**From:** Speakman, Glenn - Oxfordshire County Council  
<Glenn.Speakman@Oxfordshire.gov.uk>  
**Sent:** 26 January 2022 11:41  
**To:** Wayne Campbell; DC Support  
**Cc:** Transport CDC Minor; Cllr George Reynolds  
**Subject:** 21/04271/F Land South of Faraday House, Woodway Road, Sibford Ferris

**Planning application:** 21/04271/F  
**Location:** Land South of Faraday House, Woodway Road, Sibford Ferris  
**Description:** Erection of 6 one storey age restricted dwellings (55 years) for older people with access, landscaping and associated infrastructure  
**Case Officer:** Wayne Campbell

Oxfordshire County Council, as the Local Highways Authority, notify the District Planning Authority that they **object** to the granting of planning permission.

Rev Project 4349 Date Stage 3 Details Drawing 03 Rev L Status PLANNING

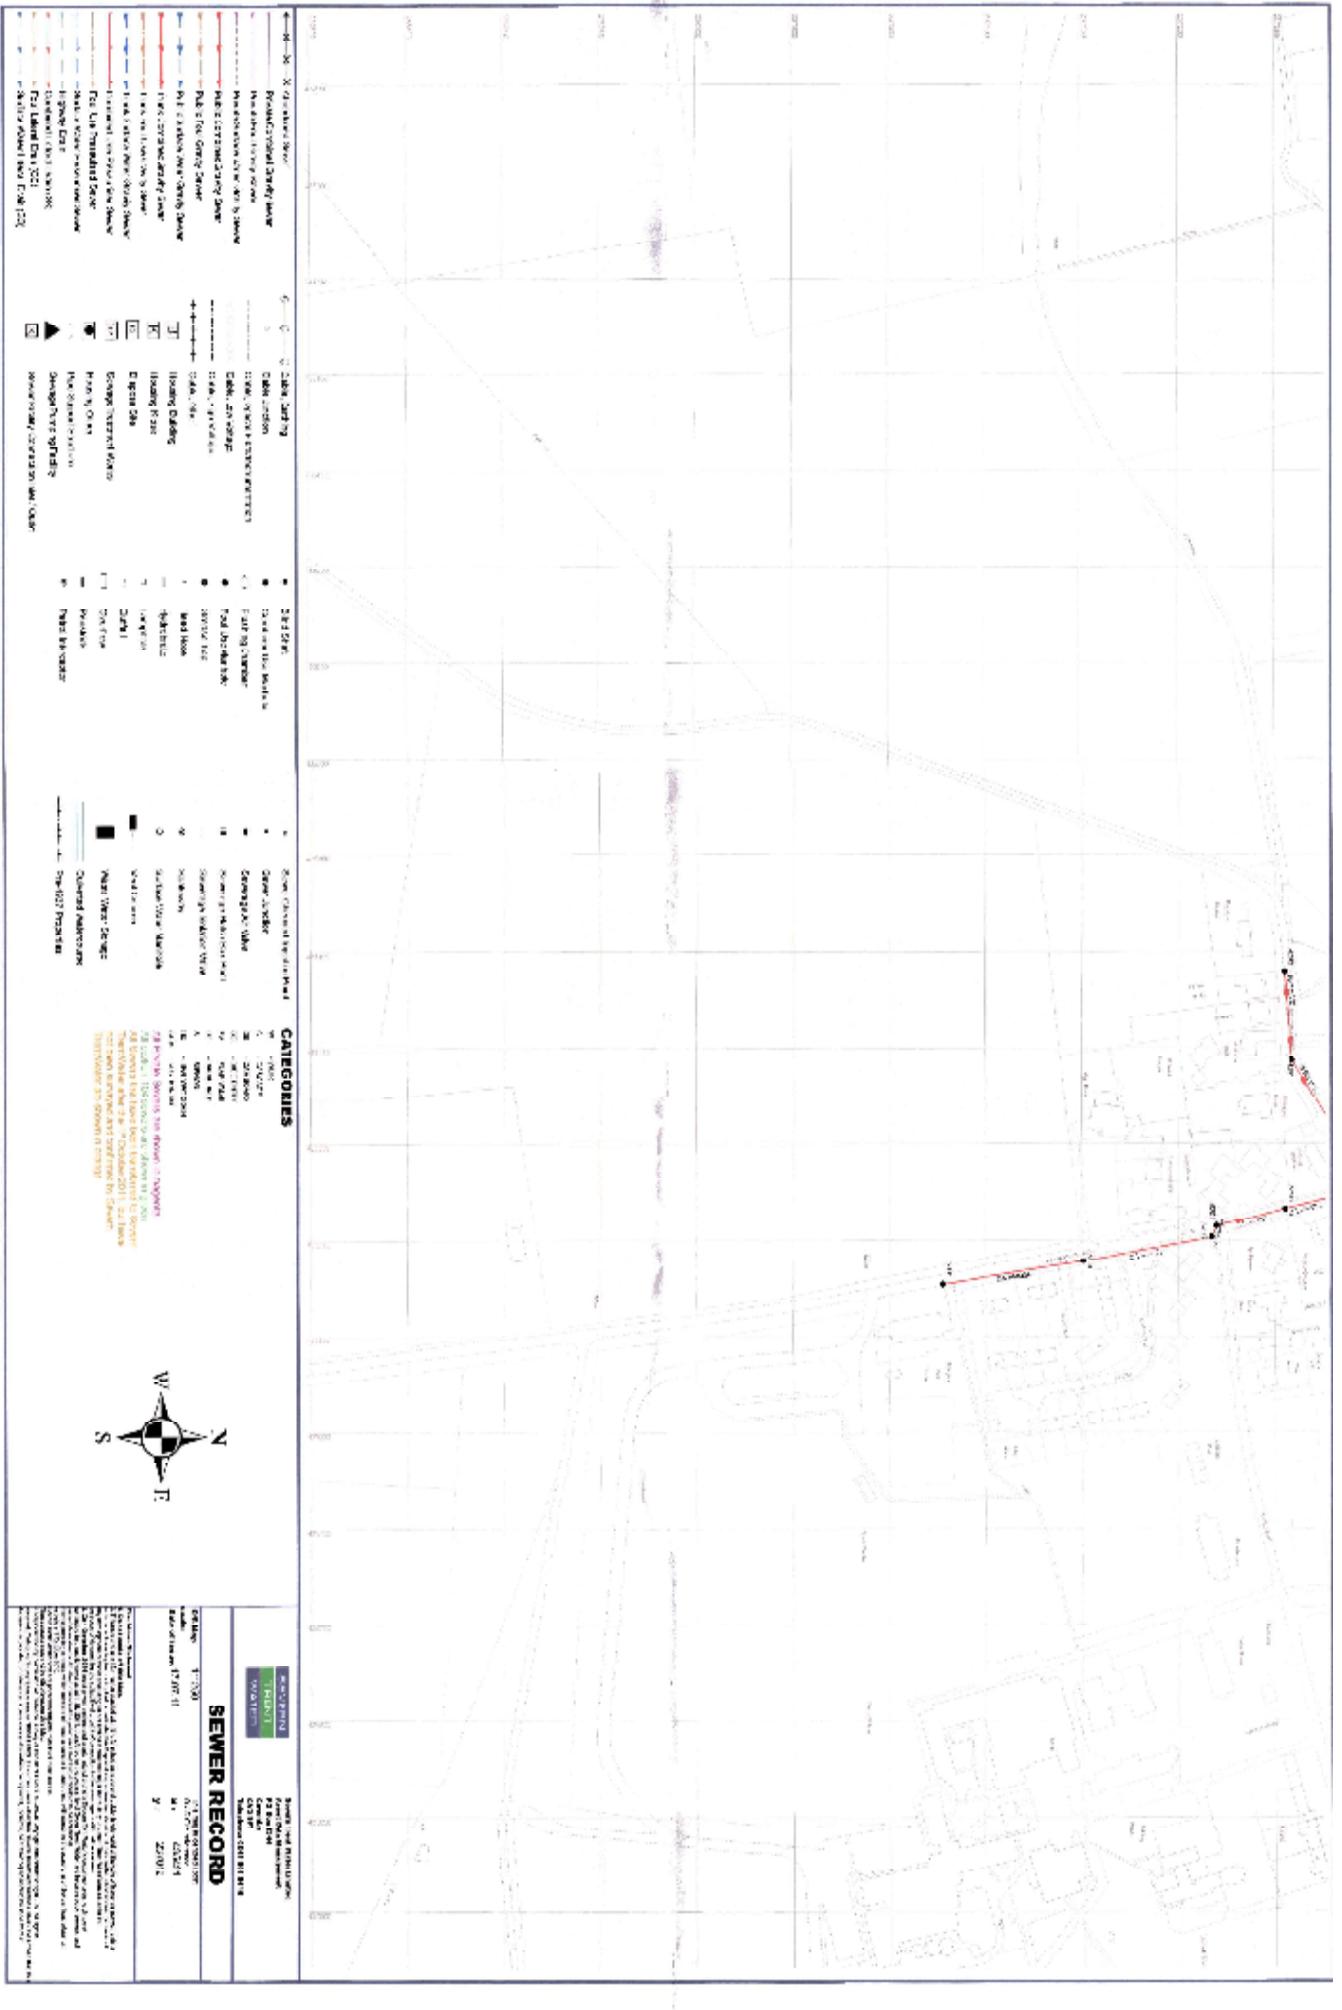
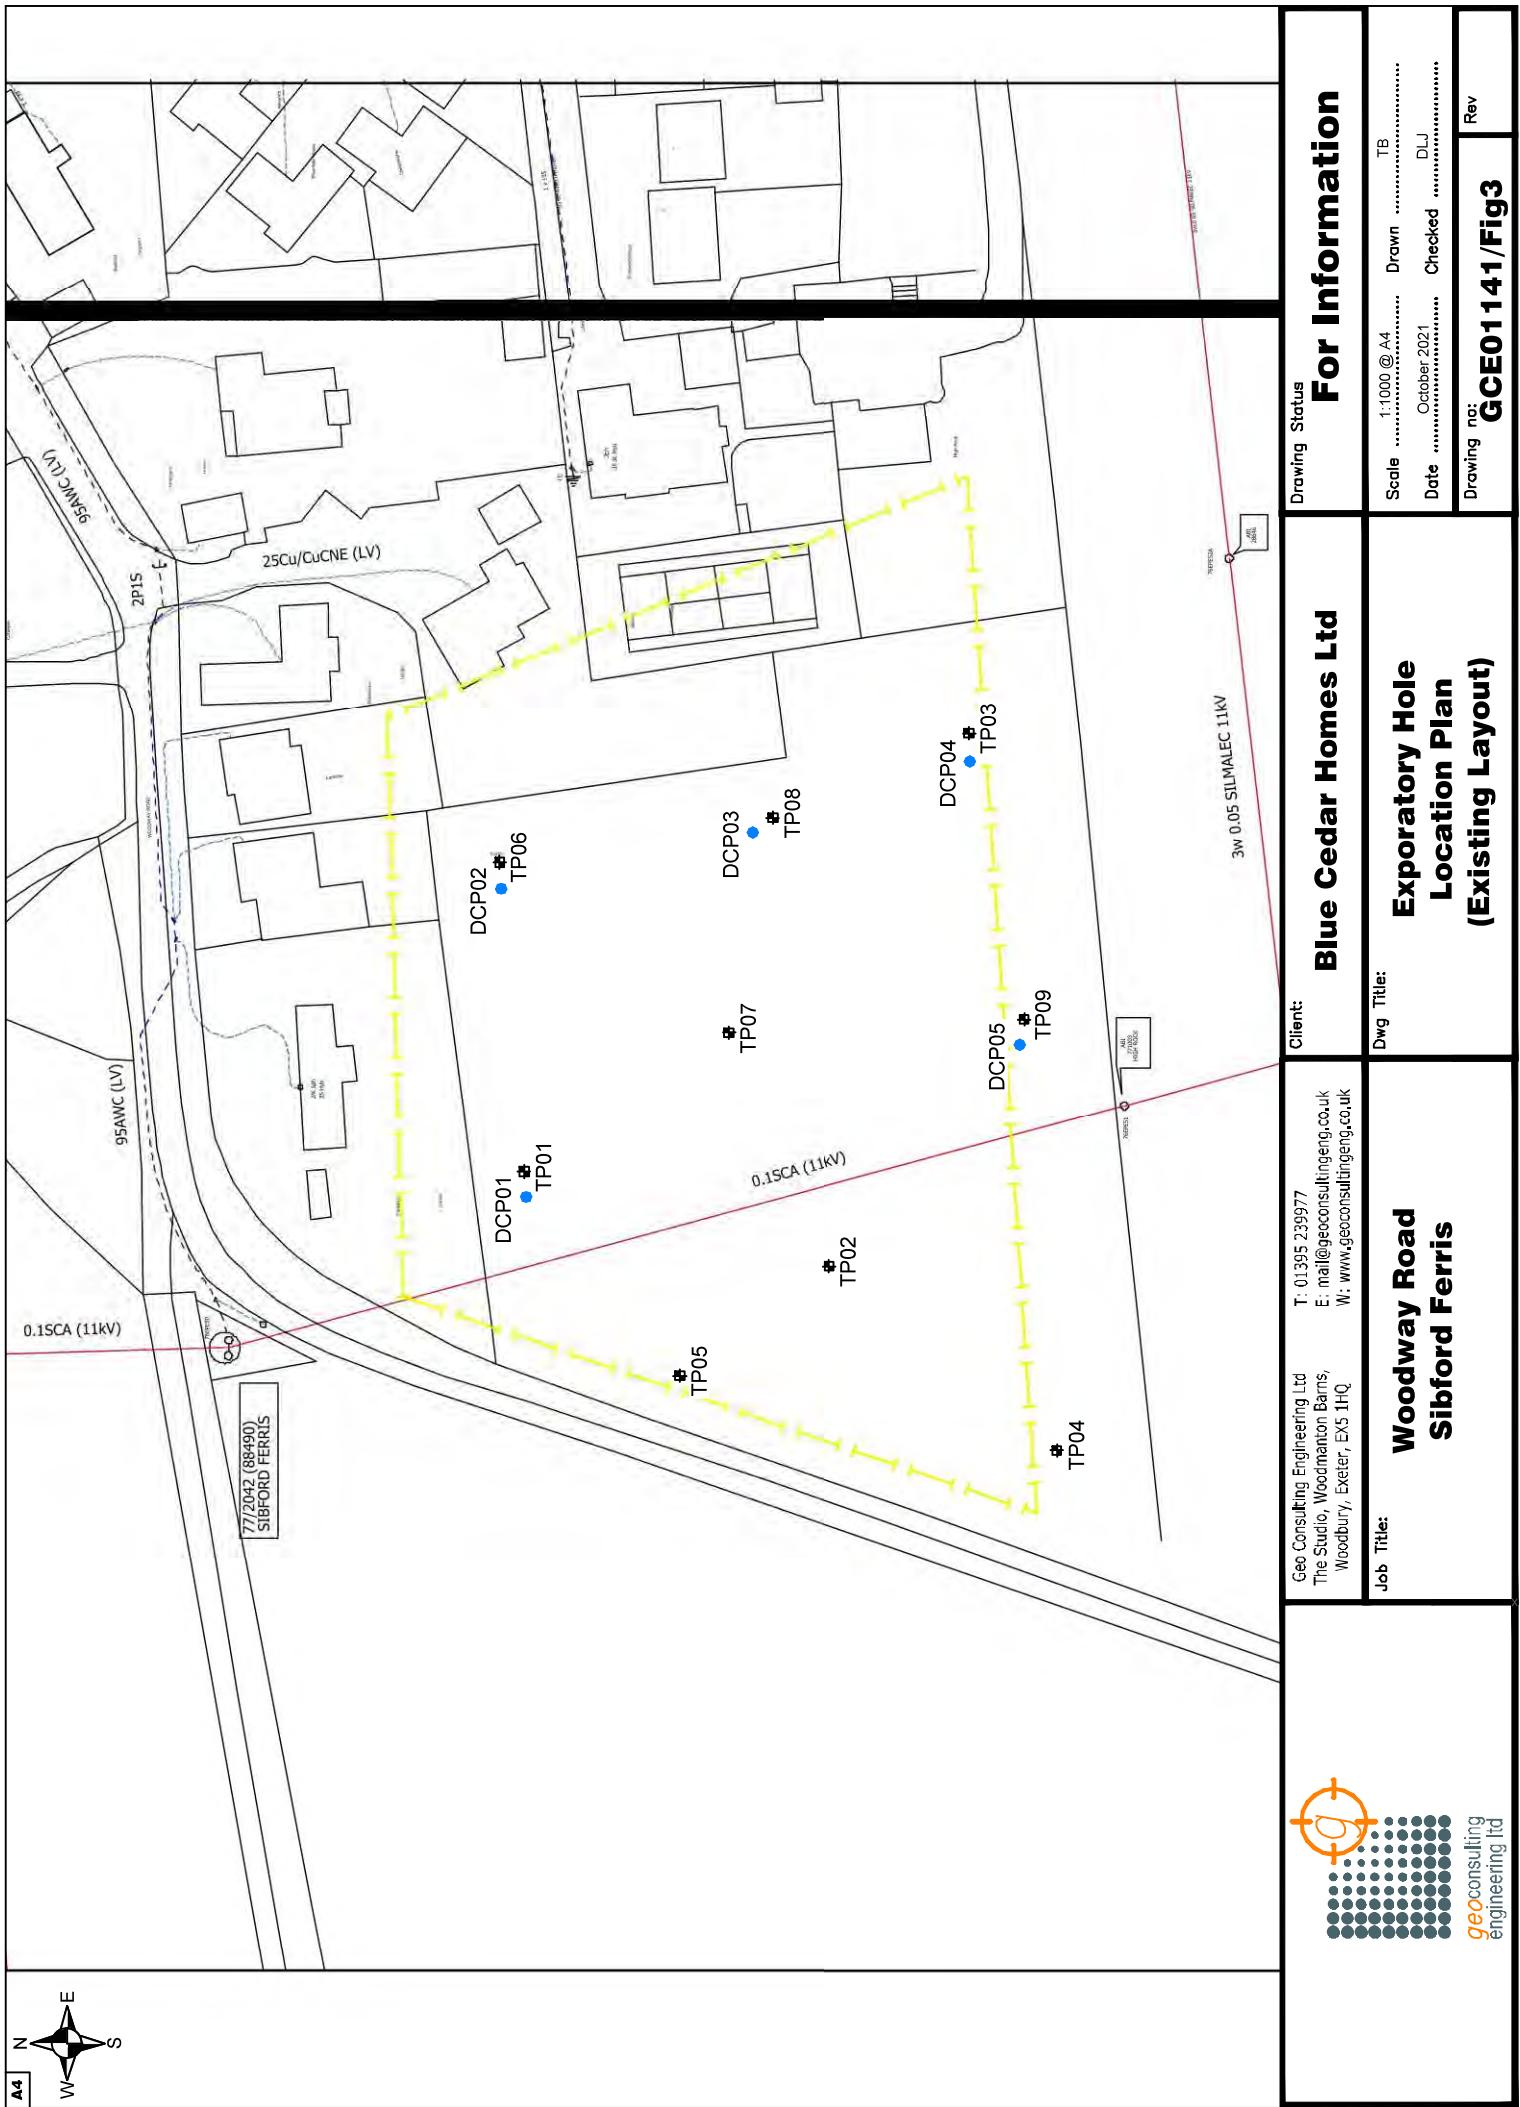
1. Service vehicle turning – The applicant has demonstrated that refuse and fire service vehicles can turn within the lower portion of the site. The applicant must also demonstrate that this is the case at the upper portion of the site. This is particularly important as plots 1, 2 and 3 are accessed via a narrow shared surface path. Service vehicles reversing long distances on this path would be a significant risk to pedestrian safety.

2. The shared access path to plots 1, 2 and 3 is too narrow. The newly adopted Oxfordshire Street Design Guide (2021) recommends a minimum width of 6m on shared access paths. It is recognised that the site will experience low speeds and a limited number of traffic movements. In light of this, it is requested that the shared access path be widened to 5m along its entirety. The right side footpath of the proposed adopted highway currently terminates abruptly at the proposed grass service strip. This should be altered to terminate at the shared access path for convenience and to protect vulnerable pedestrians.
